CITY OF ALBUQUERQUE

**RE: 13704 Ellena Gallegos NE
Grading Plan
Stamp Date: 8/8/17
Hydrology File: E24D002A**

13704 ELENA GALLEGOS	DRAWN BY WCVJ
	GRADING AND DRAINAGE PLAN	DATE 7-16-17
7/18/17 8/8/17		21740-LAYOUT-5-28-17
DAVID SOULE P.E. #14522		SHEET #
		JOB # 21740

13704 ELENA GALLEGOS	DRAWN BY WCMJ
	GRADING AND DRAINAGE PLAN	DATE 7-16-17
	 1806 CENTRAL AVENUE SE SUITE 201 ALBUQUERQUE, NM 87106 (505) 872-0898	21740-LAYOUT-5-28-17
7/18/17		SHEET #
DAVID SOULE P.E. #14522		JOB # 21740

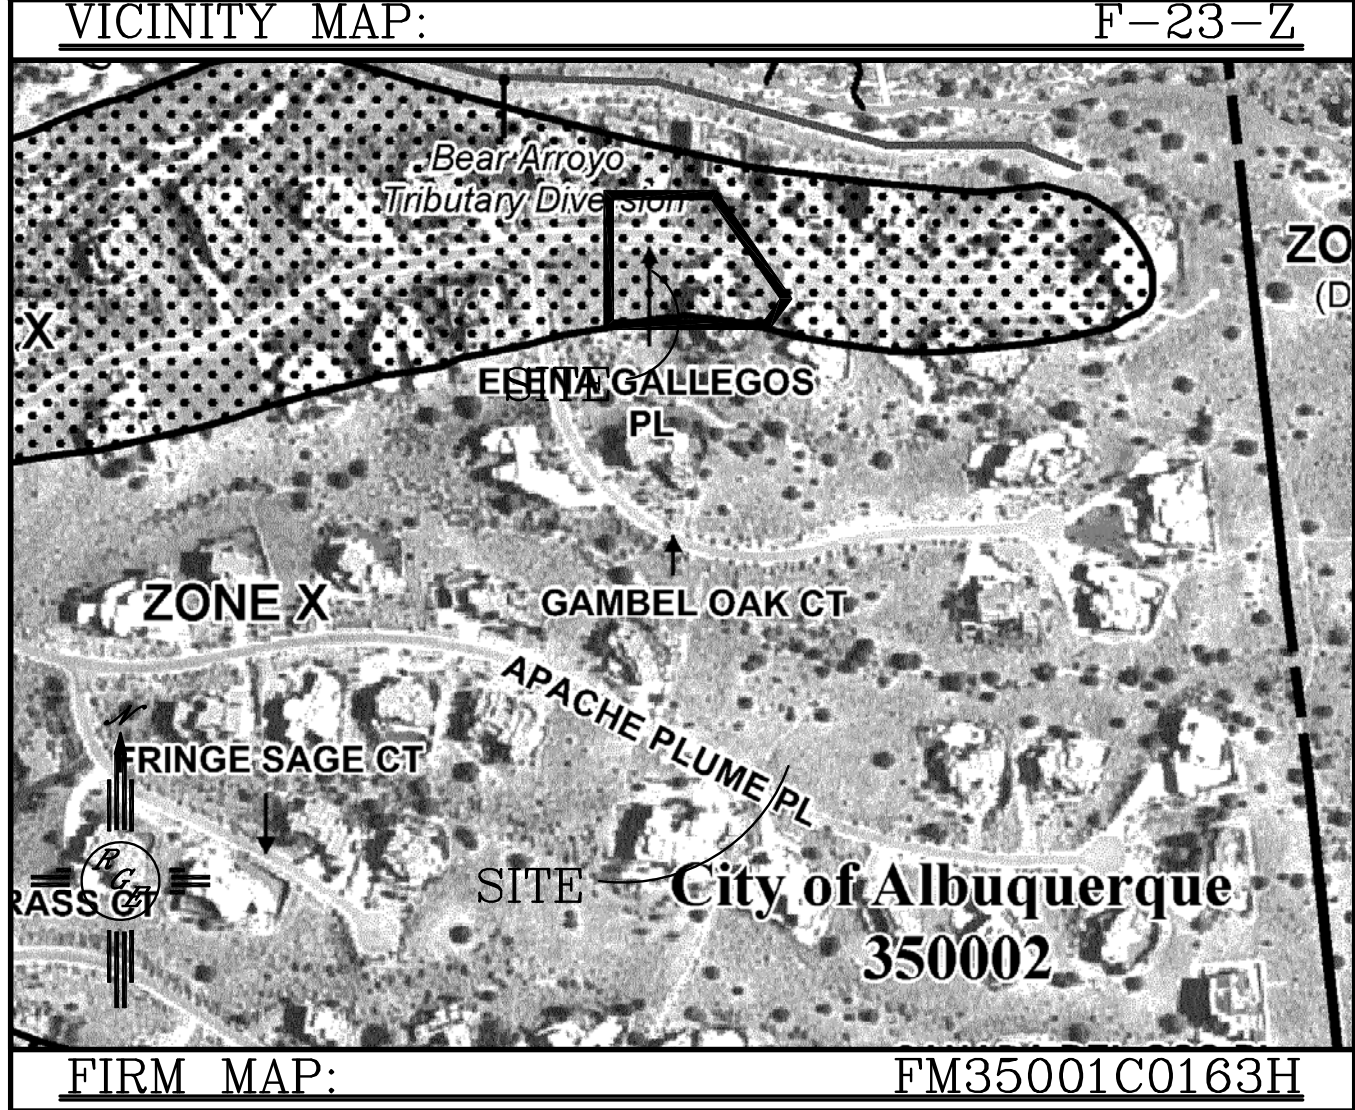
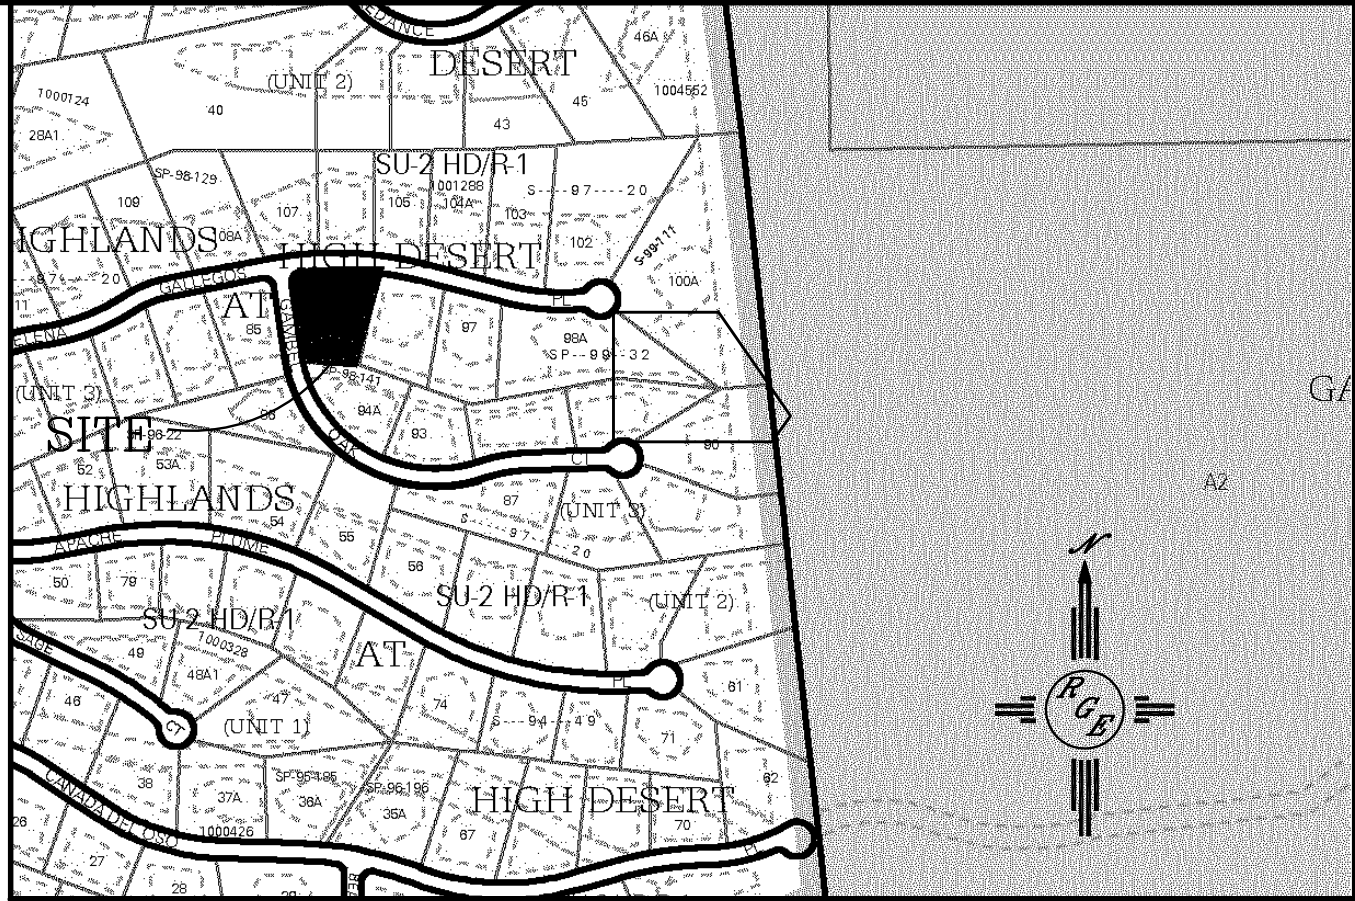
1. Please provide both the beginning and ending flowlines for all the cobble swales.
WE HAVE ADDED THE INVERT ELEVATIONS
2. Please add the weir calculations for the emergency overflows.
WE HAVE ADDED TO THE CAACLULATIONS
3. There is enough room on the sheet, so please enlarge the Site Hydrology calculations and notes. **WE ENLARGED**
